CITY OF PORTLAND

BUILDING PERMIT

Job ID: 2011-11-2790-DRG

has permission to 32' x 28' Detached Garage w/ a Second Floor Exercise Room.

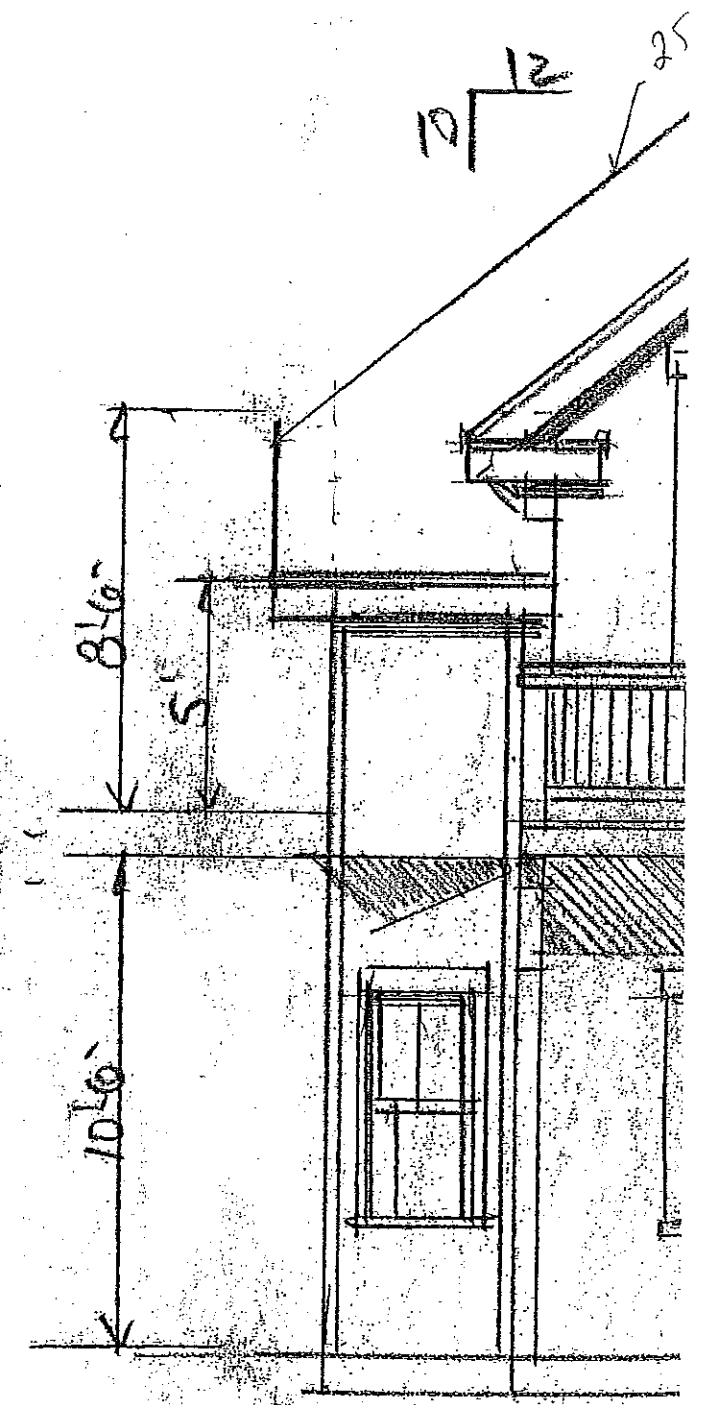
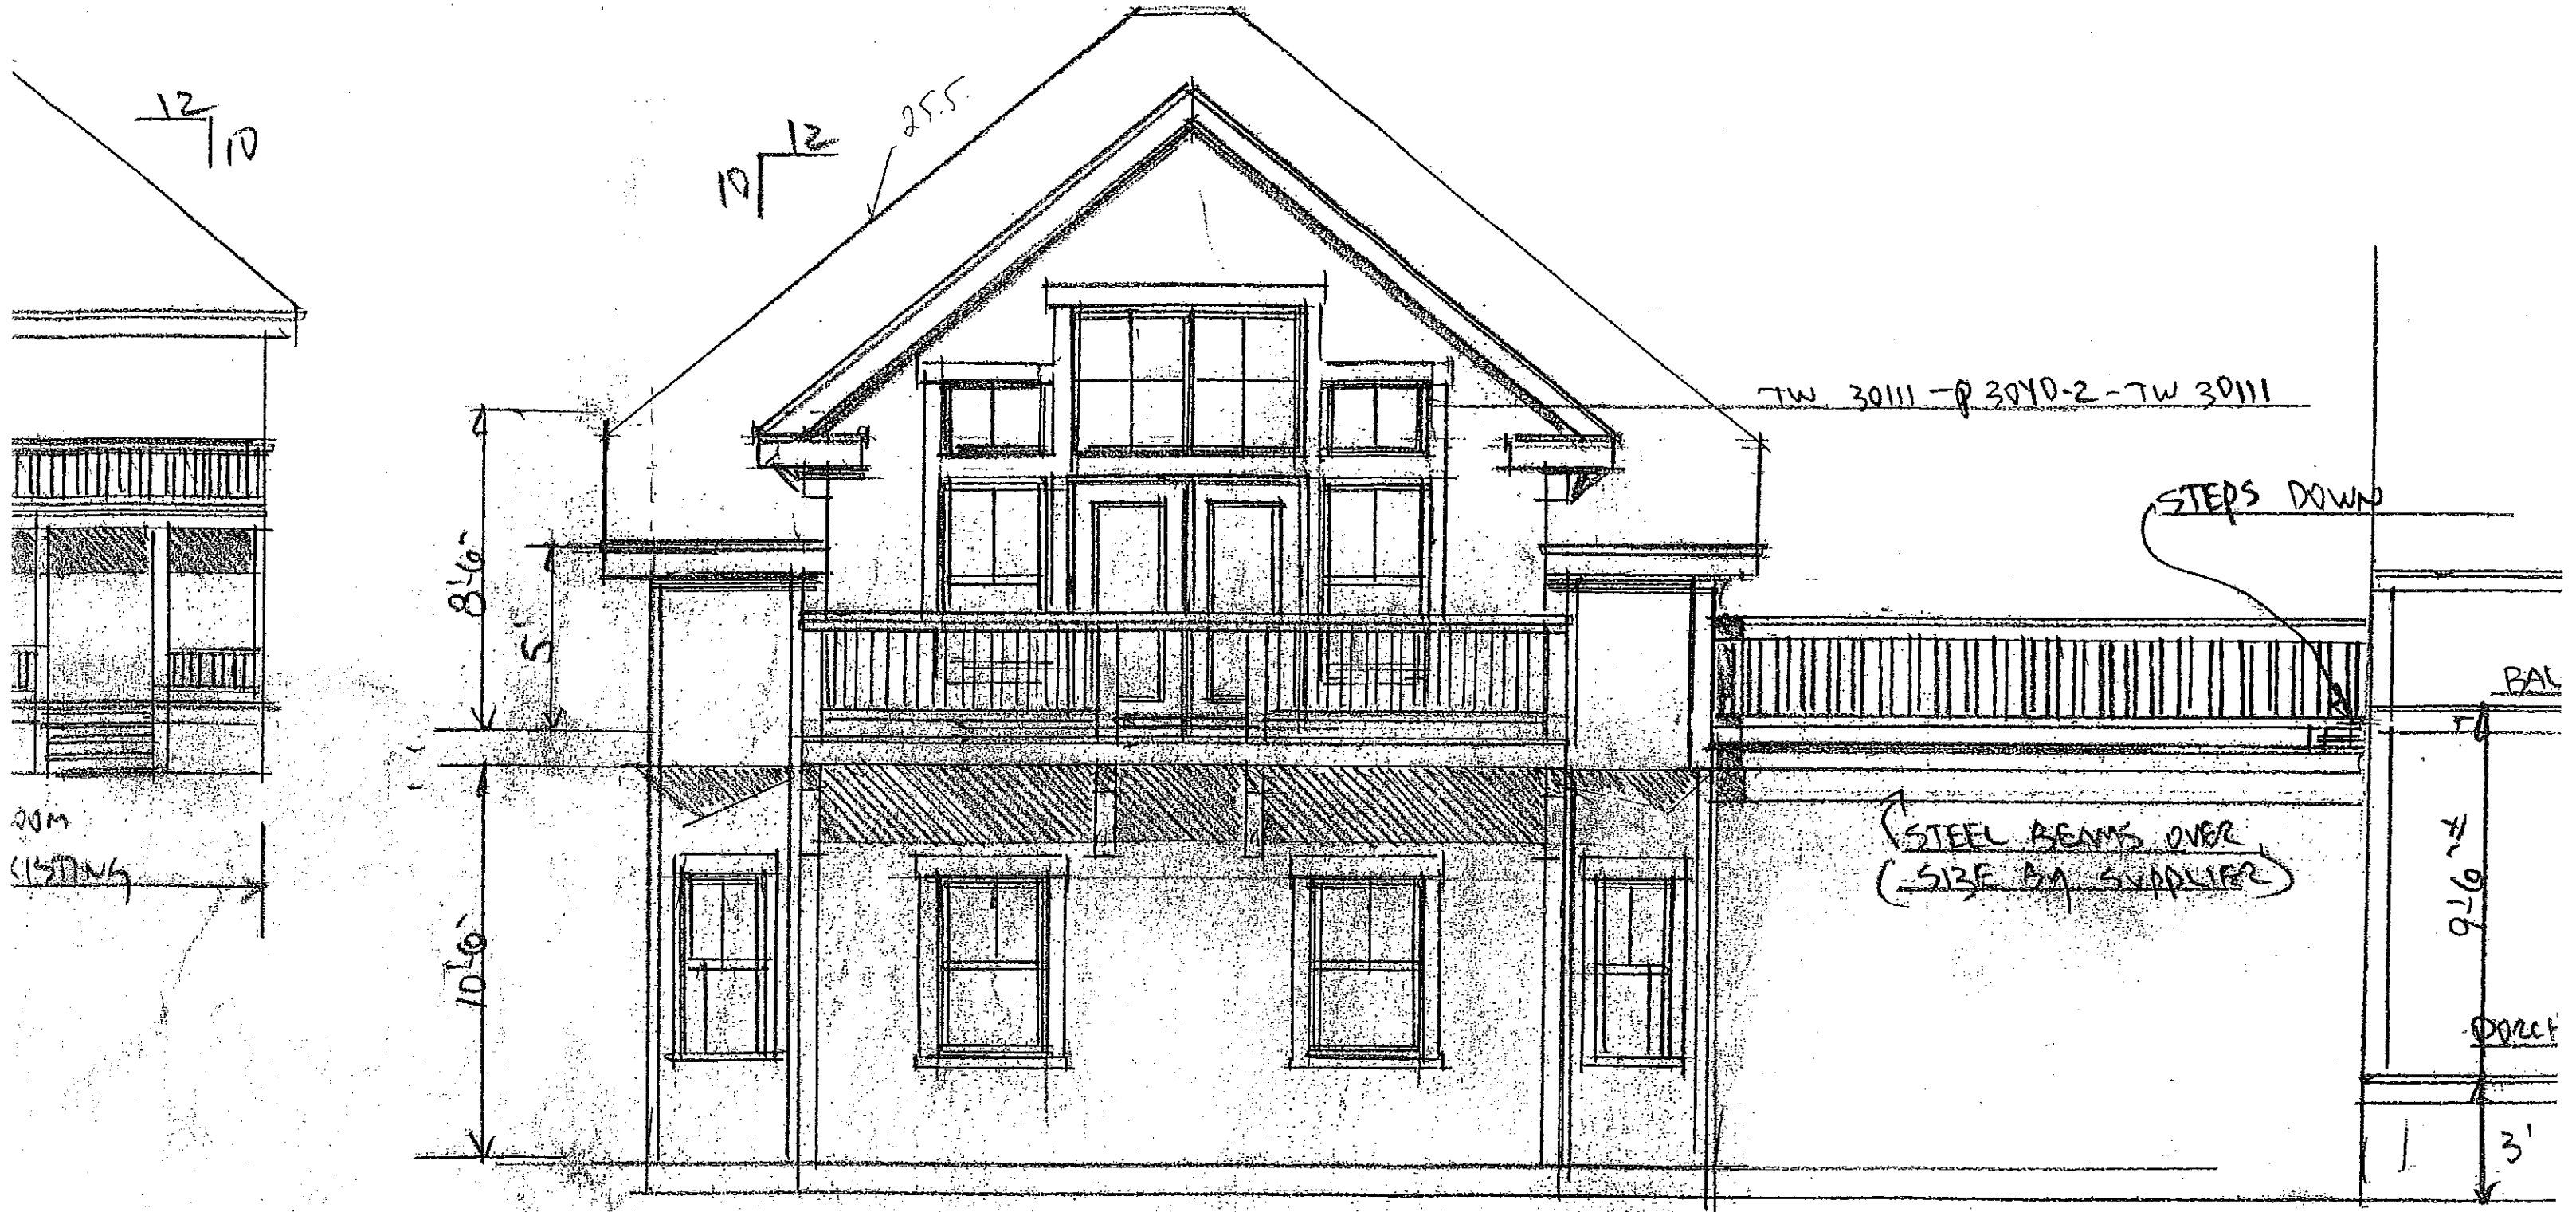
3. **Roof Rafter framing and Connection shall comply with Section R802.3 & R802.3.1 of MUBEC. Note: Owner will submit plans for a code compliant Hip Roof.**
